Article 21 of the Town and Country Planning (General Development Procedure) Order 1995
Application to discharge condition number 5 on planning permission WA/59/11
West Walberton Farm West Walberton Lane, Walberton,

Arun District Council have decided to **REFUSE** details reserved by condition for the **following reasons:**

Proposed Floor Plan Showing Soakaways

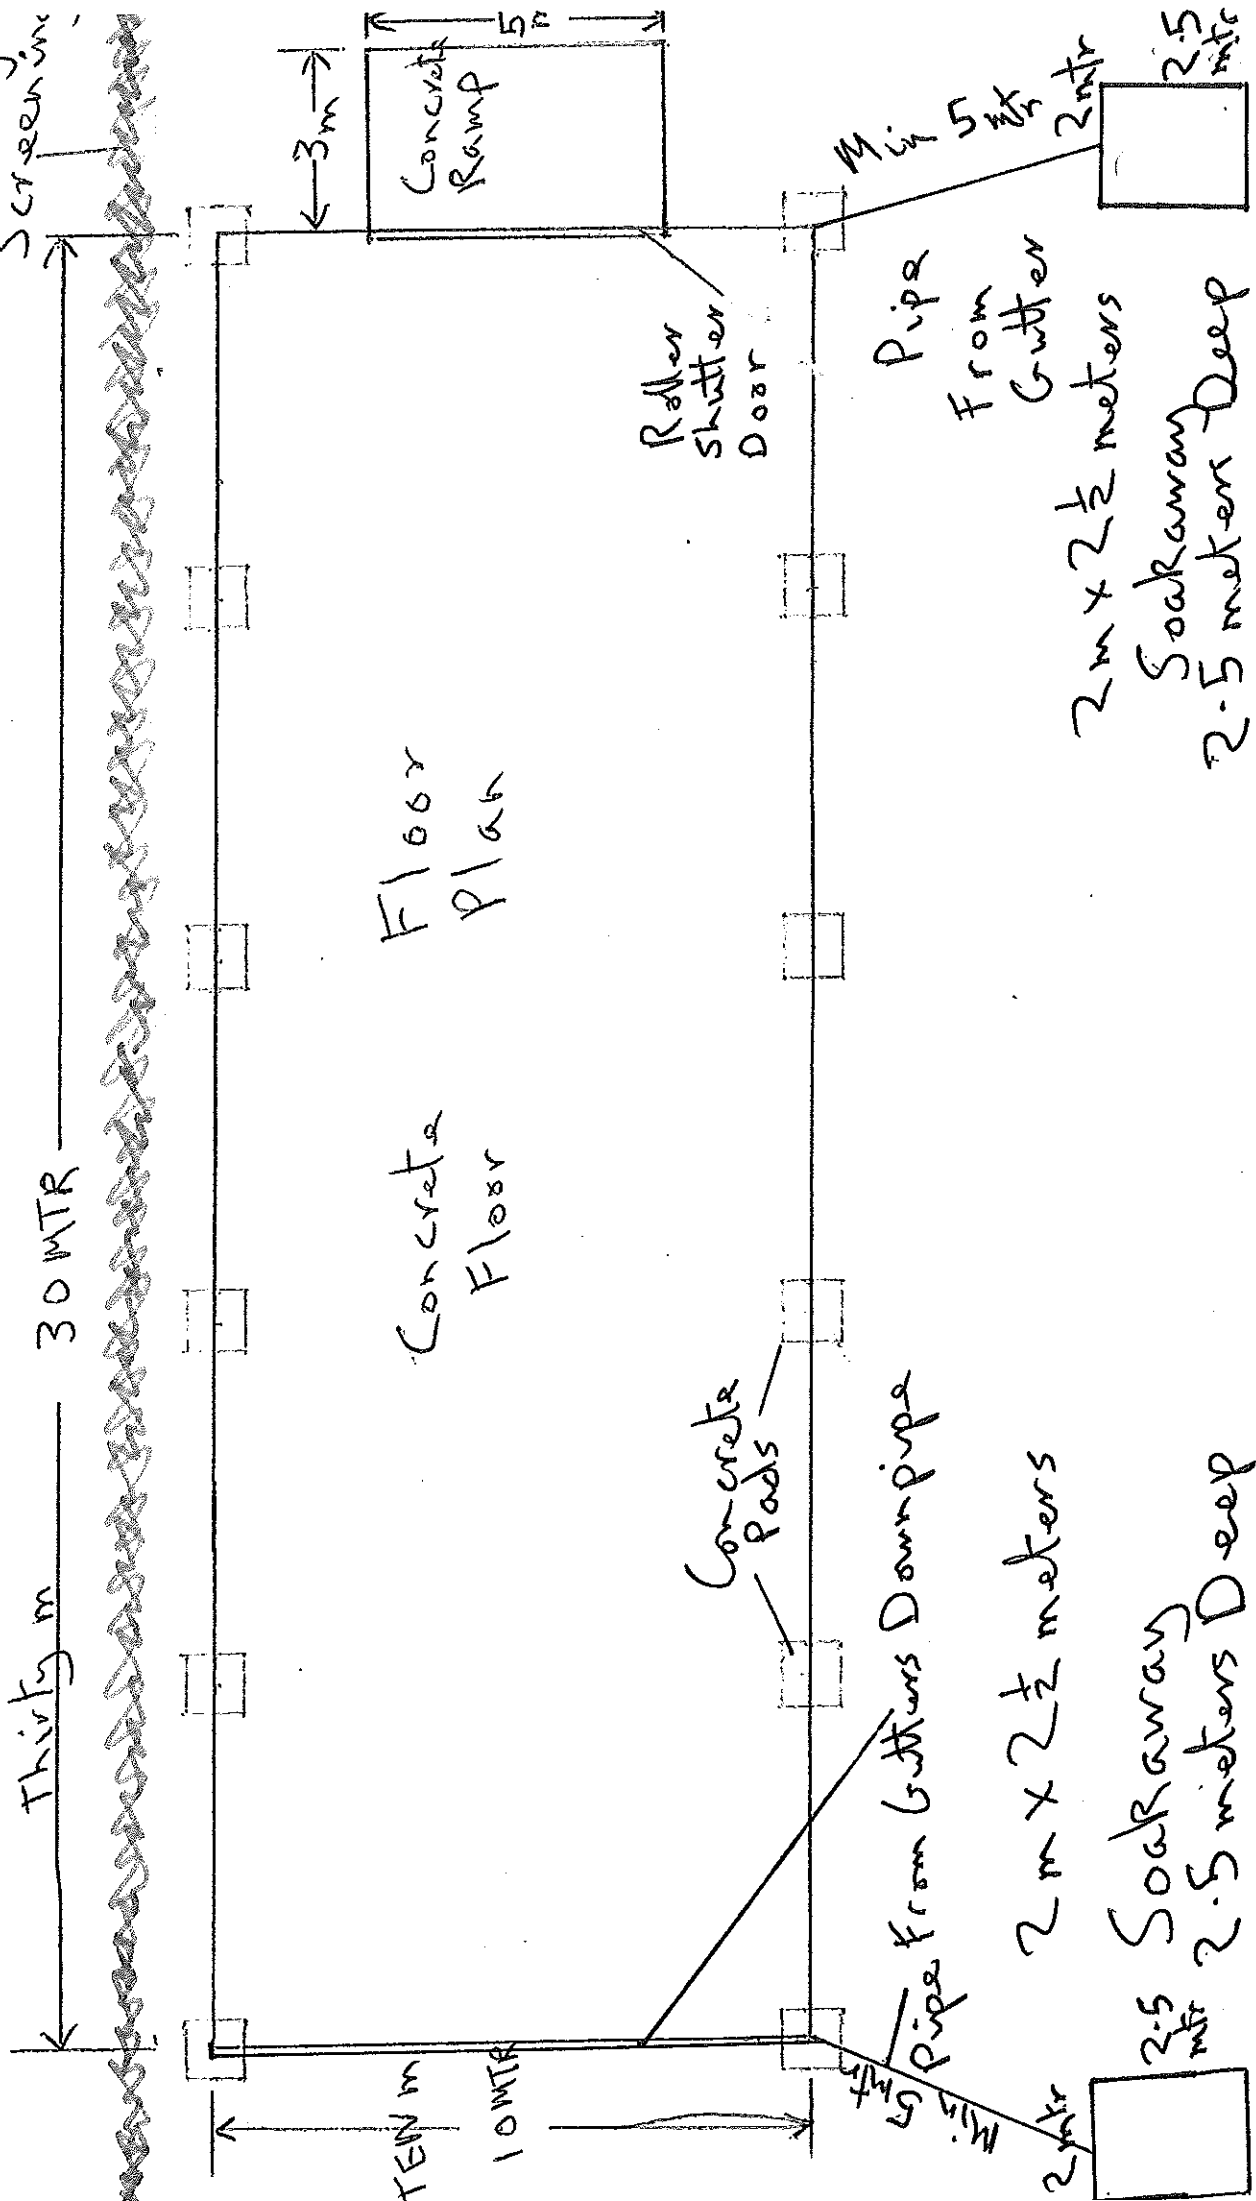
Insufficient information has been submitted to discharge the condition. The design requires calculation to BRE365 with winter ground water monitoring and percolation testing to support. The base of the soakaway must not be below the ground water table and should store a 1 in 10 year rainfall event below the invert of the pipe and a 1 in 100 year rainfall event plus 30% below ground level.
